CONSULTEE RESPONSE (Council's Arboriculturist)

Reference: A/102/22/PL

Proposal: 1 No new dwelling. This application is a Departure from the Development Plan and is in CIL Zone 3 and is CIL Liable as new dwelling

Location: Land rear of Oakhurst House and Huntington House, West Drive, Angmering

SITE LAYOUT PLAN AS PROPOSED

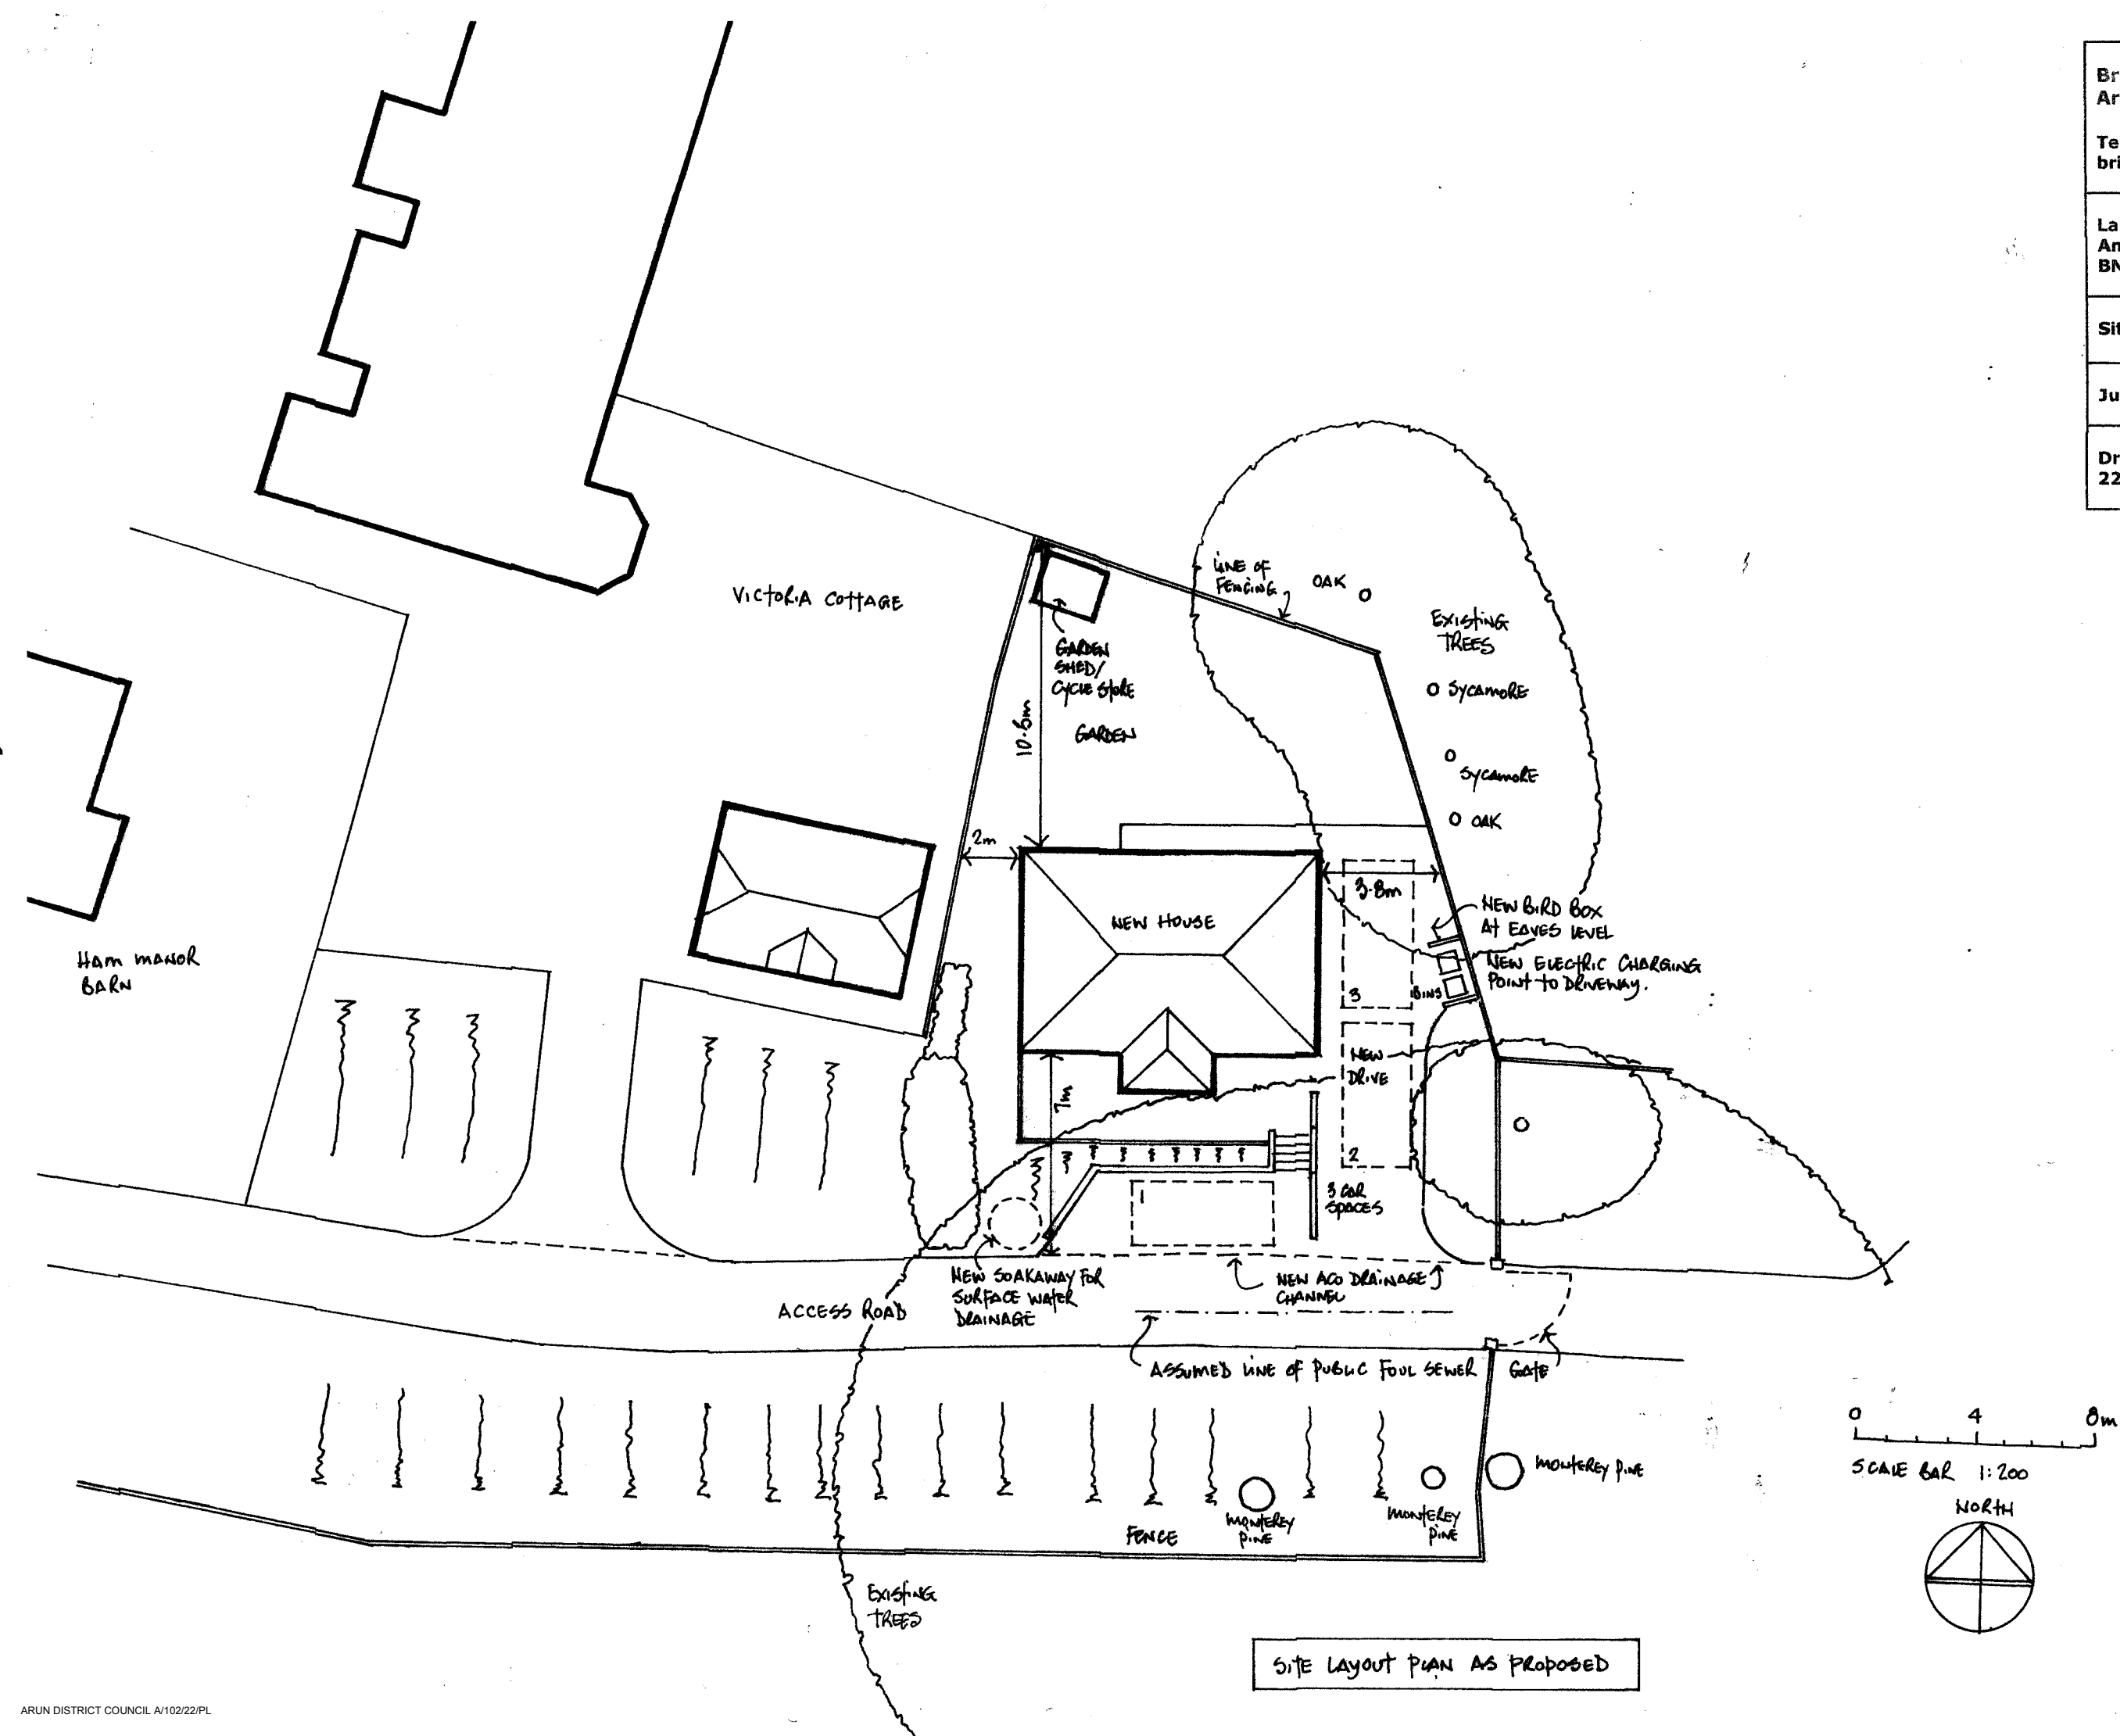
The relationship between ground levels of the proposed vehicle access and driveway ('no-dig construction') and adjacent areas has not been described in detail or shown on any cross-section drawing. The viability of this critical element of the development proposal must be revealed via civil engineering exercise, so we can be sure 3rd party preserved trees will not suffer damage and that finished ground levels in a broader context will be acceptable.

I suggest orientating the dwelling to face southeast would provide opportunity for a more harmonious relationship with those established trees (use of garden space) and alternative driveway configuration if ground levels do not support 'No-dig' construction.
